273 Presumpscot St - Change of use permit (Zachary Cover)

I'm in the process of reviewing a permit application submitted by Zachary Cover, for the conversion the use of the small building on Hascall & Hall's property to a medical marijuana grow business. Unfortunately, I've encountered a significant problem.

A-2.1

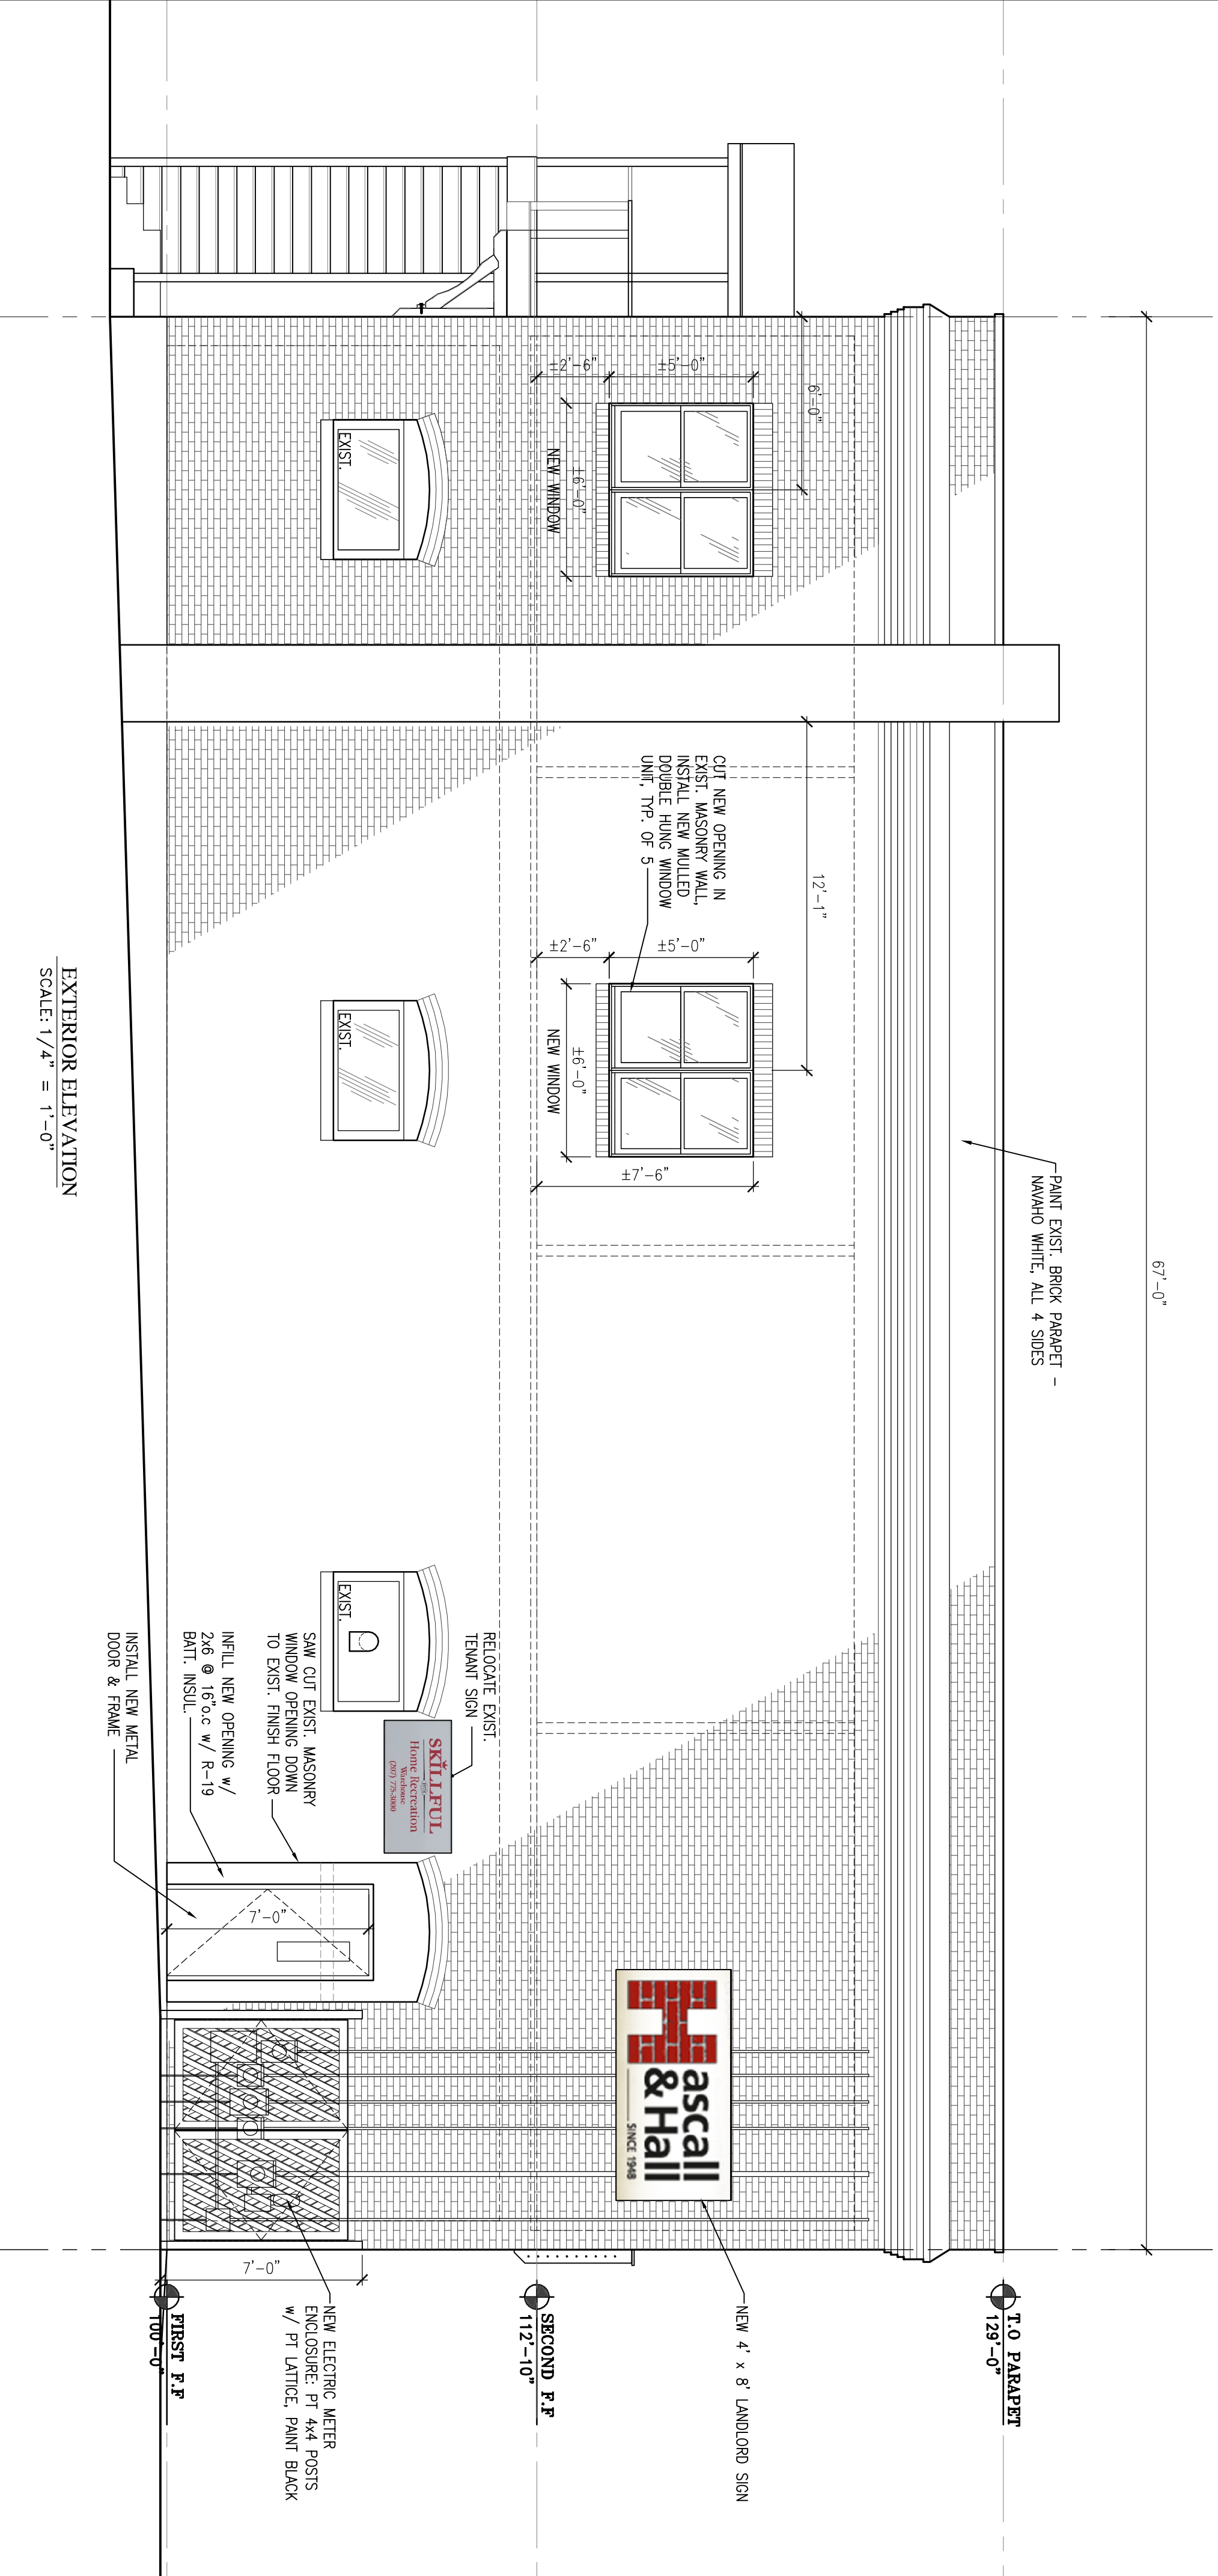
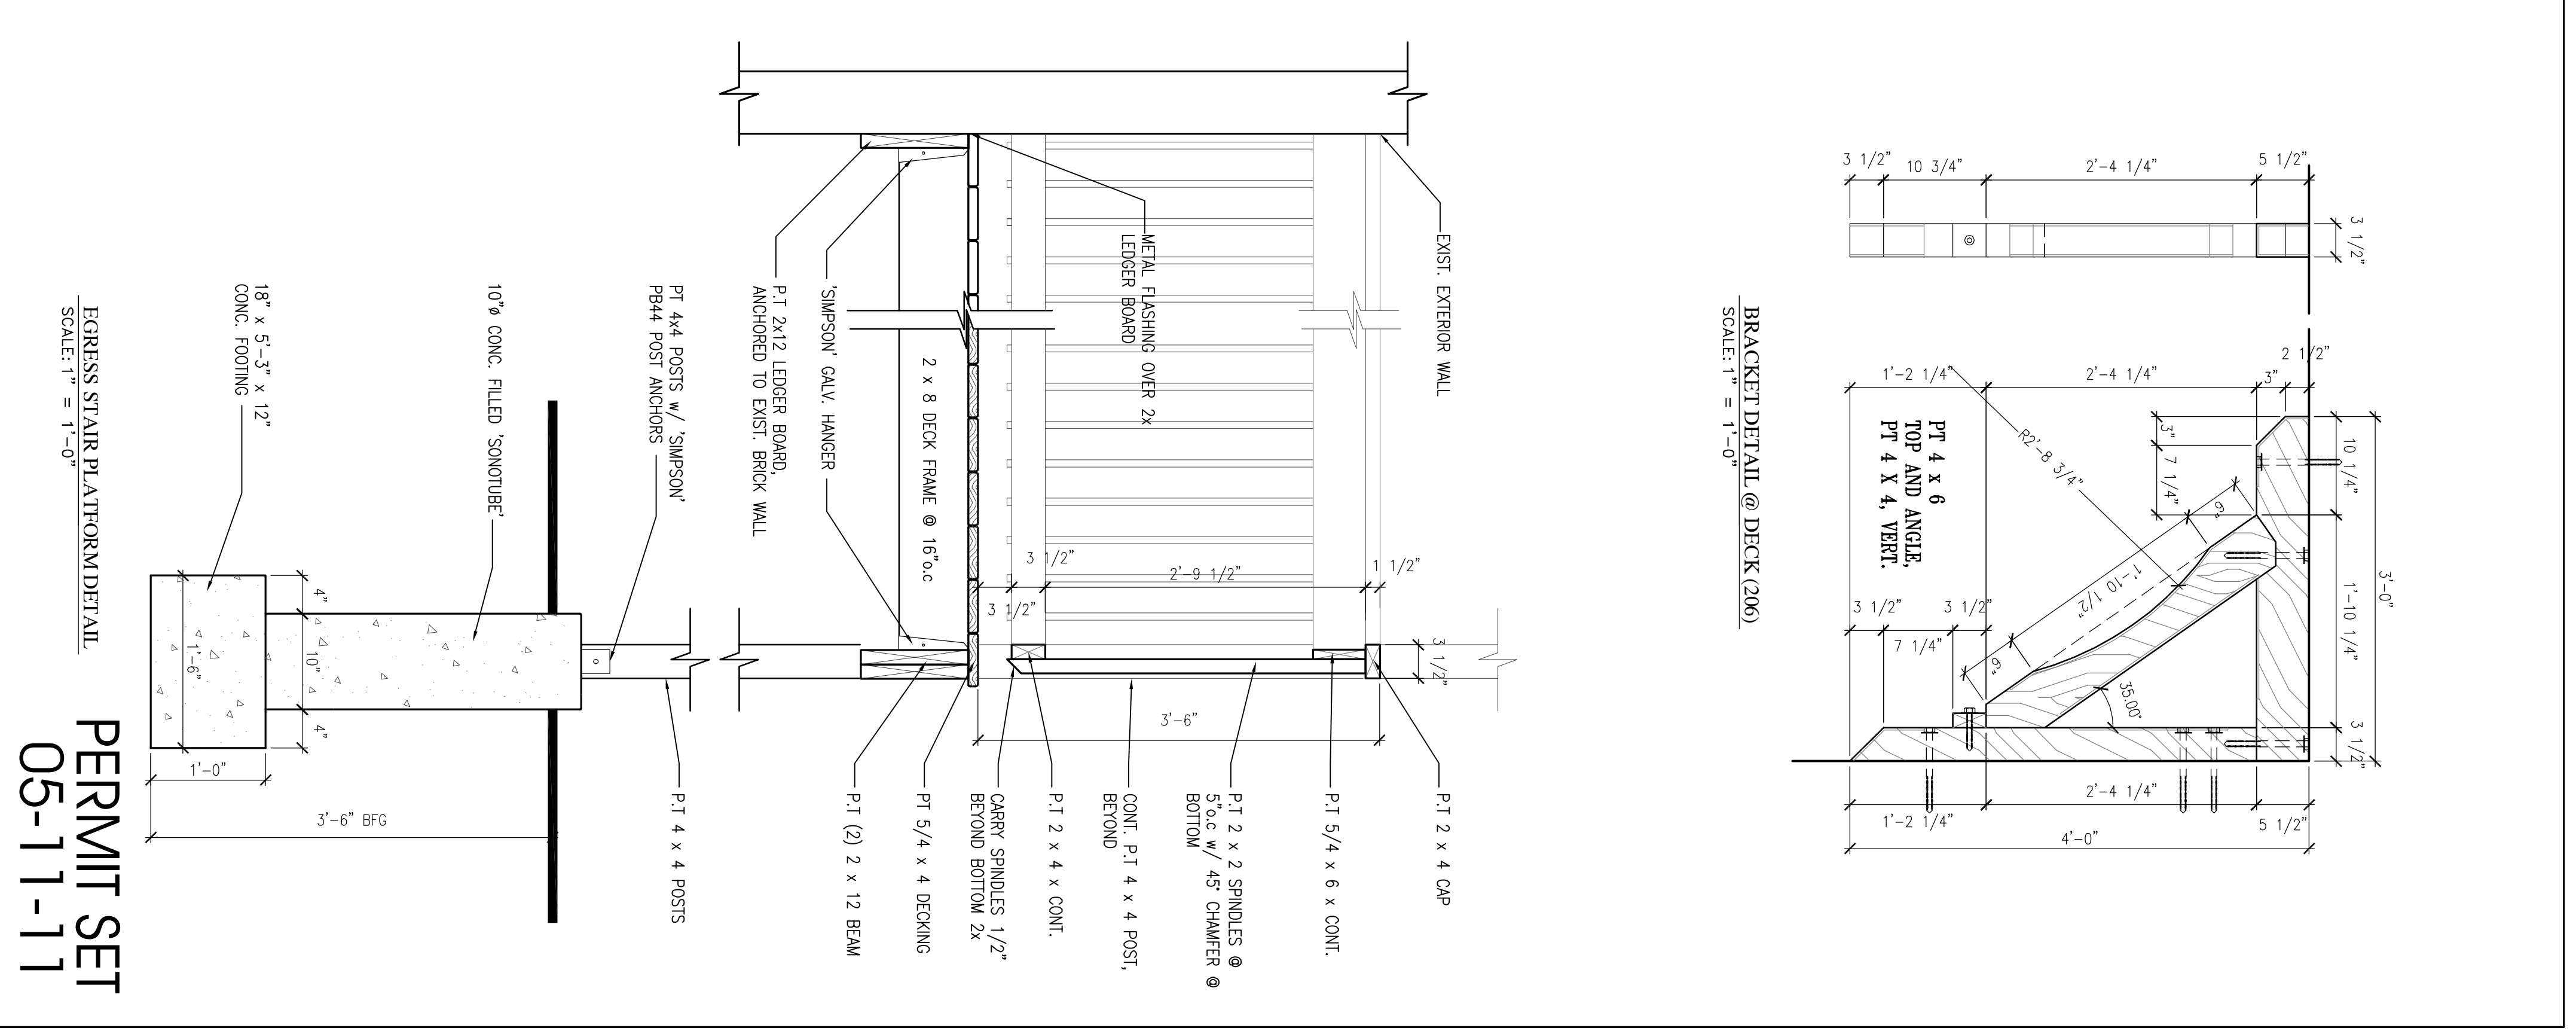
I also noticed that a deck appears to have been constructed on the rear of this building without any apparent permit approval. An after-the-fact building permit should be submitted for the deck if it will remain.

Regarding the deck, this is not new. We repaired it, but it is not a new structure.
